Application No: FP/1/25/HH
Site Address: 2 Leverton Avenue Felpham PO22 7RA
Description of works: Retrospective application for erection of a side boundary fence.

Felpham Parish Council object to this application:

updated block plan

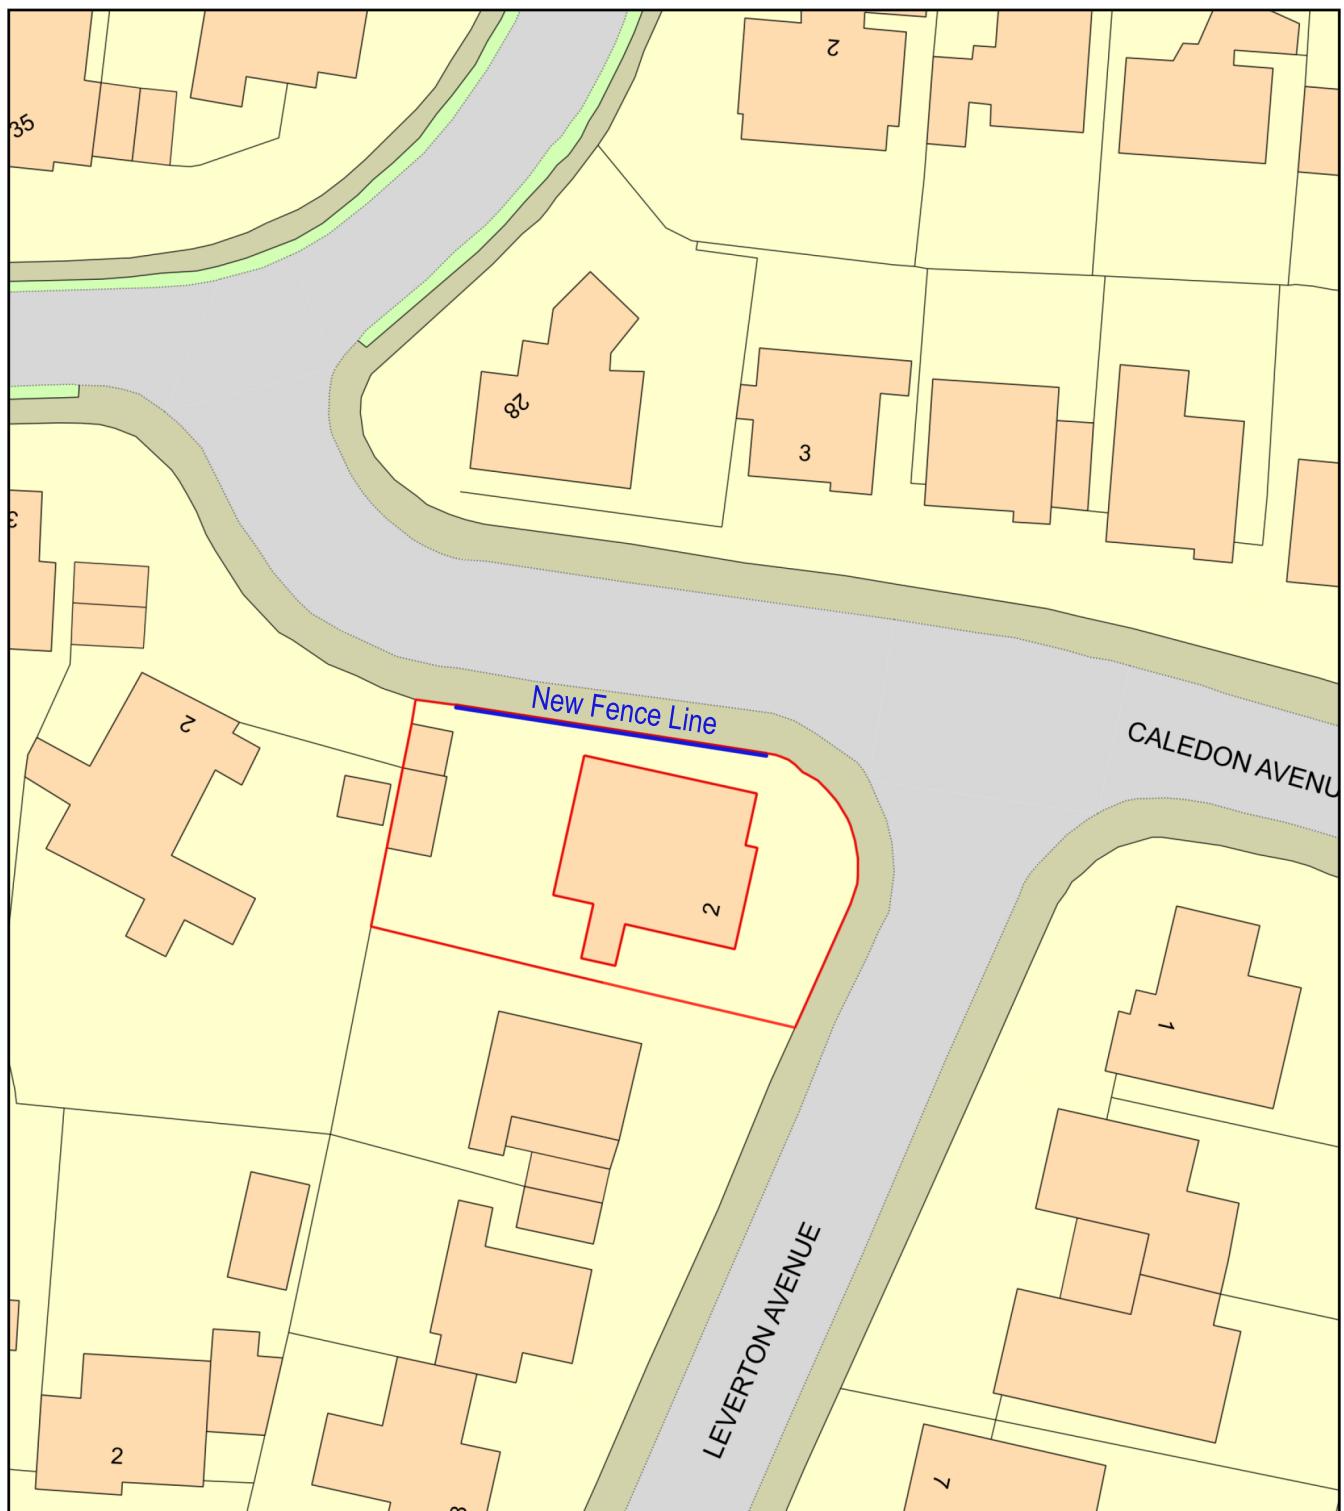
The boundary fence is considered to be an incongruous feature in the street scene and detrimental to the character and appearance of the area in conflict with policy ESD1 of the Felpham Neighbourhood Plan.
